**NELSON GEOTECHNICAL  
ASSOCIATES, INC.**

Geotechnical Plan Review Letter  
**Hu Residence Development**  
**30XX – 69<sup>th</sup> Avenue SE**  
**Mercer Island, Washington**  
NGA File No. 11448B20

**C-3.00**

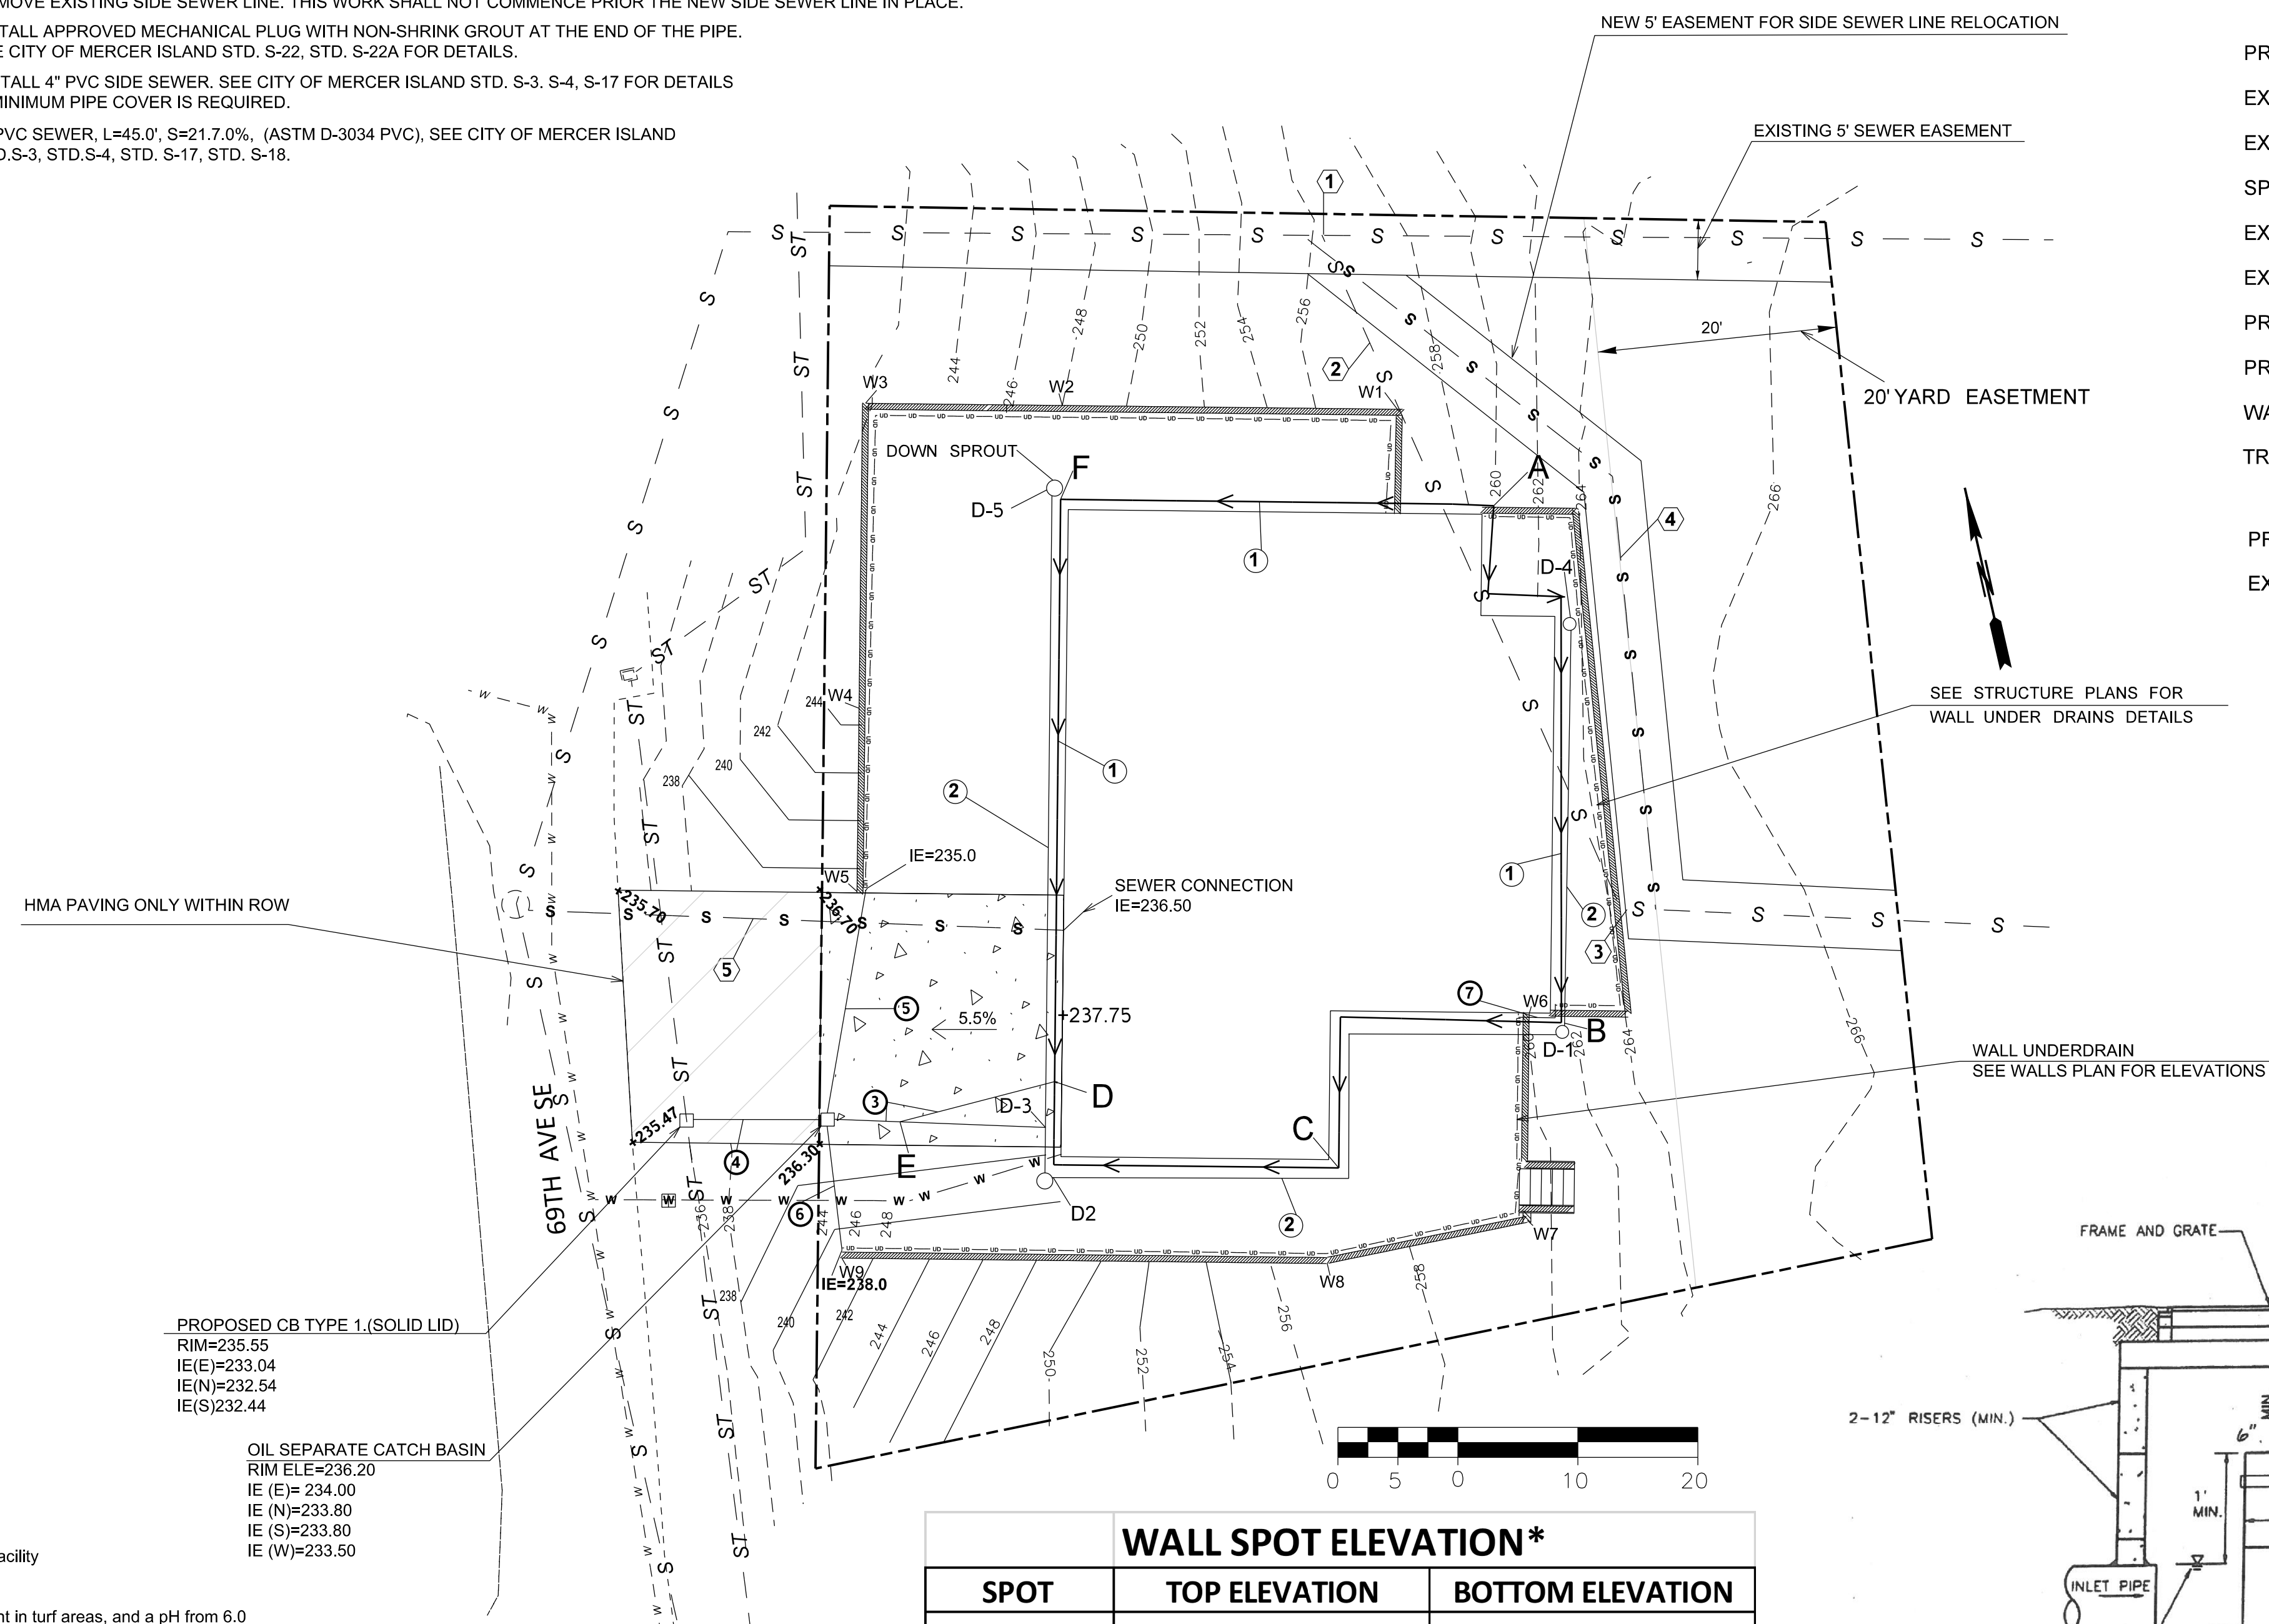
A City review comment on Sheet C3.00 concerns depths and inclination of temporary excavations for the removal and replacement of some sewer piping in the eastern part of the site. Where worker access is needed at the base of sewer excavations, any such excavation more than 4 feet deep should be shored using an excavation trench box or should be sloped at an inclination of 1.5H:1V or flatter. Trench boxes should be used in accordance with manufacturer's recommendations. Worker access in any excavation should comply with all applicable OSHA/WISHA regulations.

PROJ. NO.	20-50
SHEET NUMBER	SH2.0

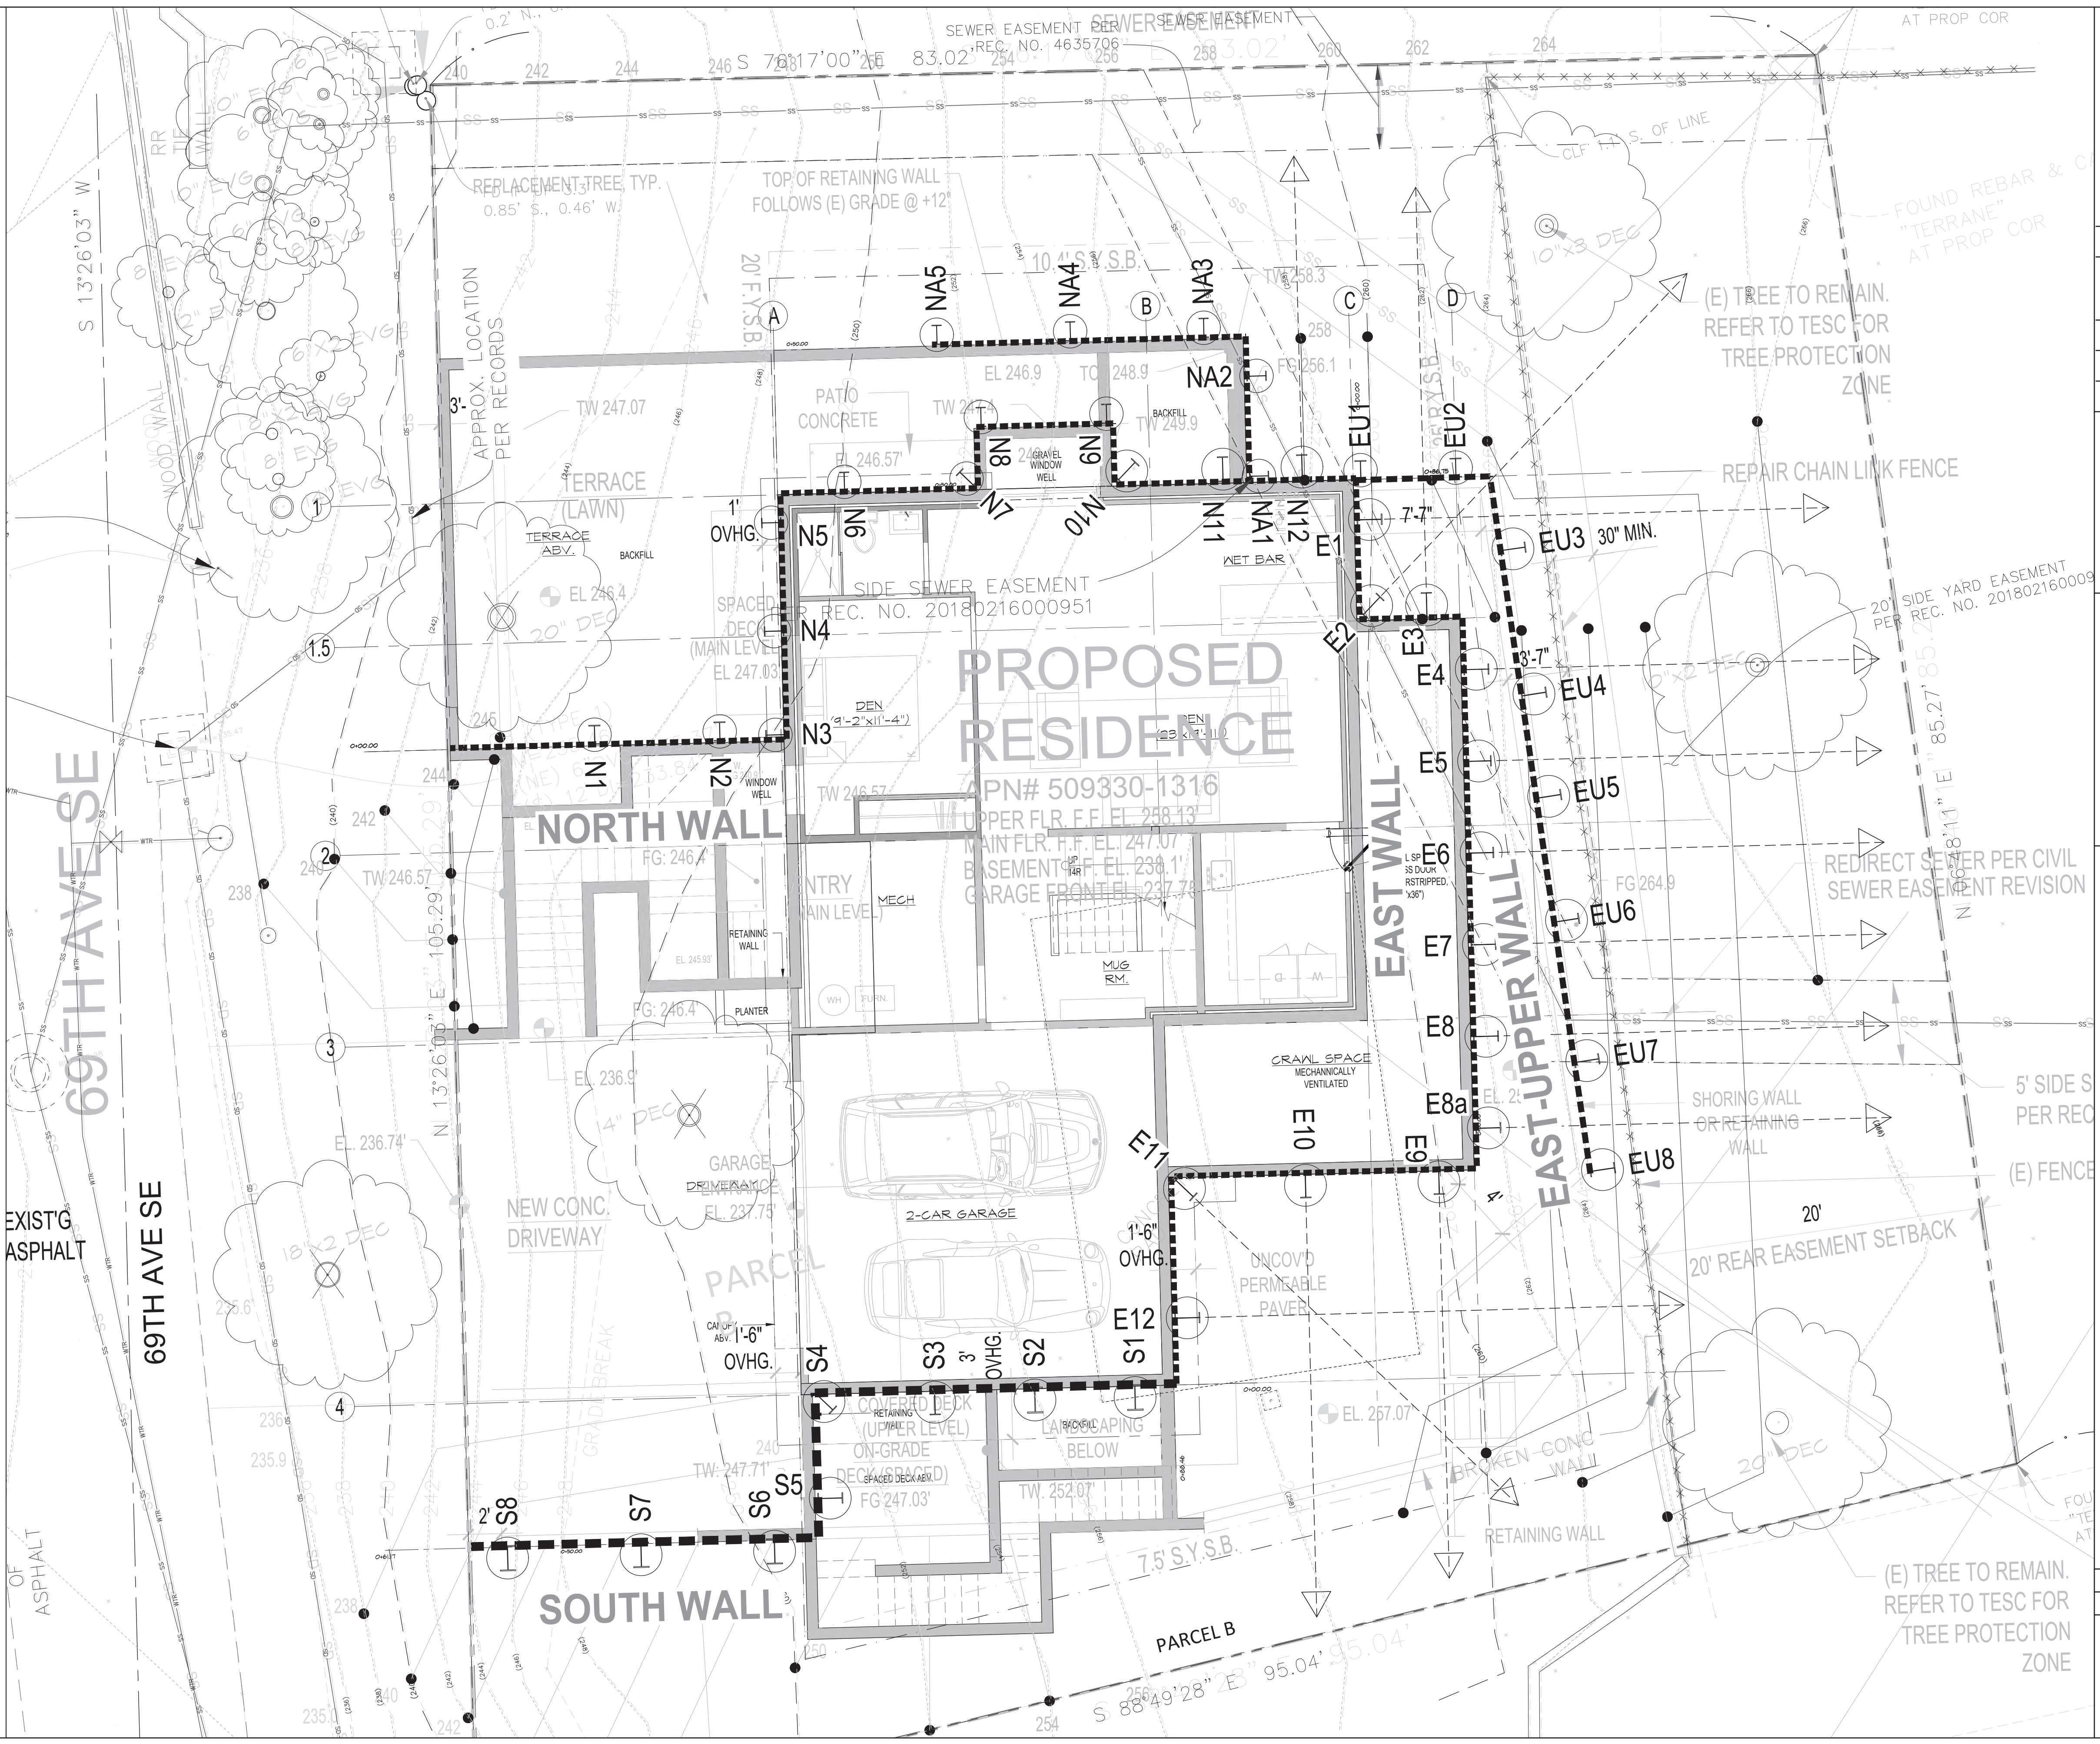
A City review comment on **Sheet SH2.0** concerns a proposed retaining wall protecting a tree in the southeast portion of the site, and the potential for the wall to impose a surcharge on excavation shoring. Plans show that the tree is 25 feet from the nearest excavation shoring and no retaining wall is shown between the tree and the shoring, thus no wall surcharge will be imposed on the shoring.
